**Planning Application Ref:** AW/236/19/T

**Location:** Royal Bay Court, 86A Barrack Lane, Aldwick, PO21 4DY

**Description of works:** Crown reduction 4m on north aspect and 2.5m on other aspects to 1no. willow tree

REF 1

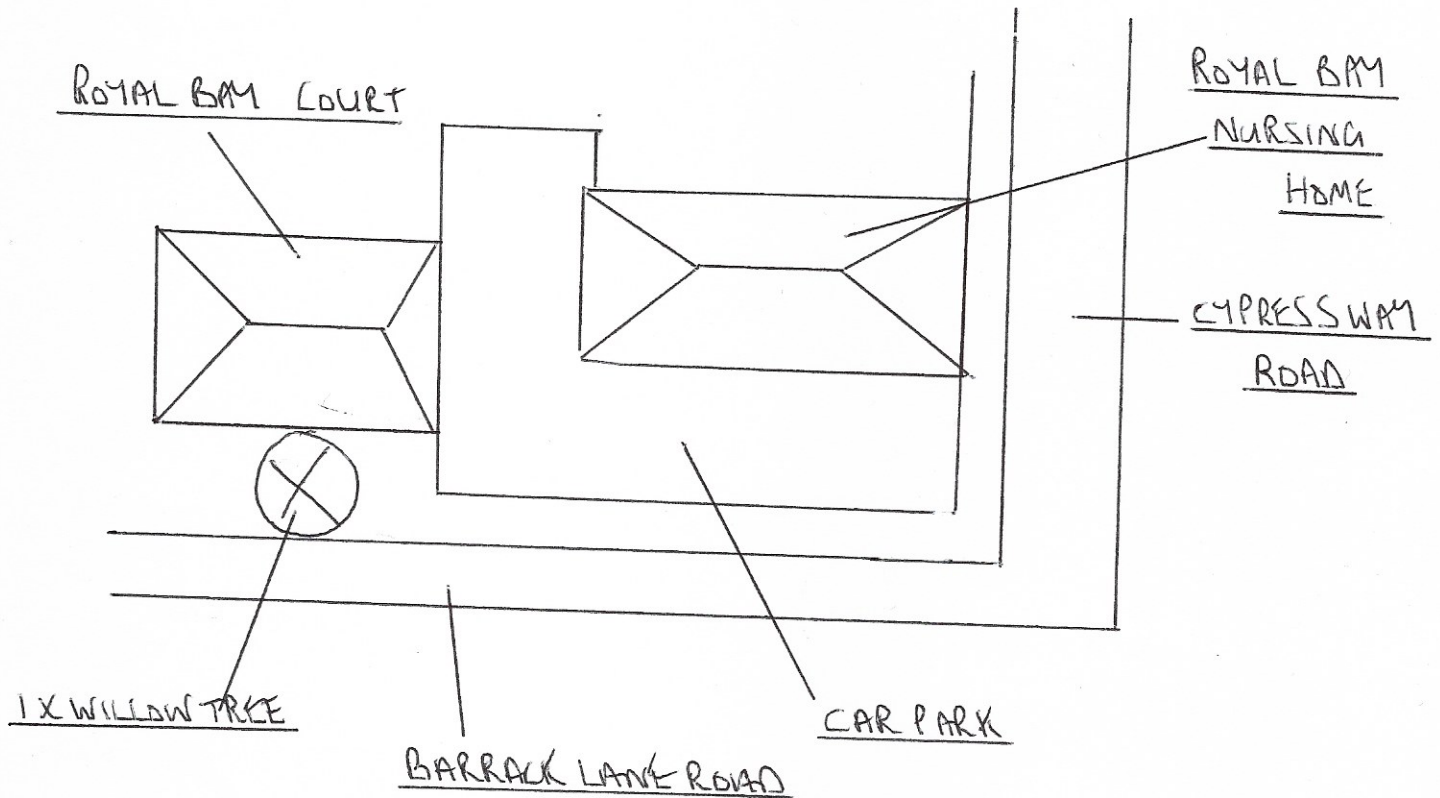
- The map provided with the application does not seem to reflect the physical features on the ground and so the marked location of the tree is not helpful. That said, I have sought verbal confirmation from the applicant who confirms the tree subject of this application is the large, obvious and only mature willow on the site.
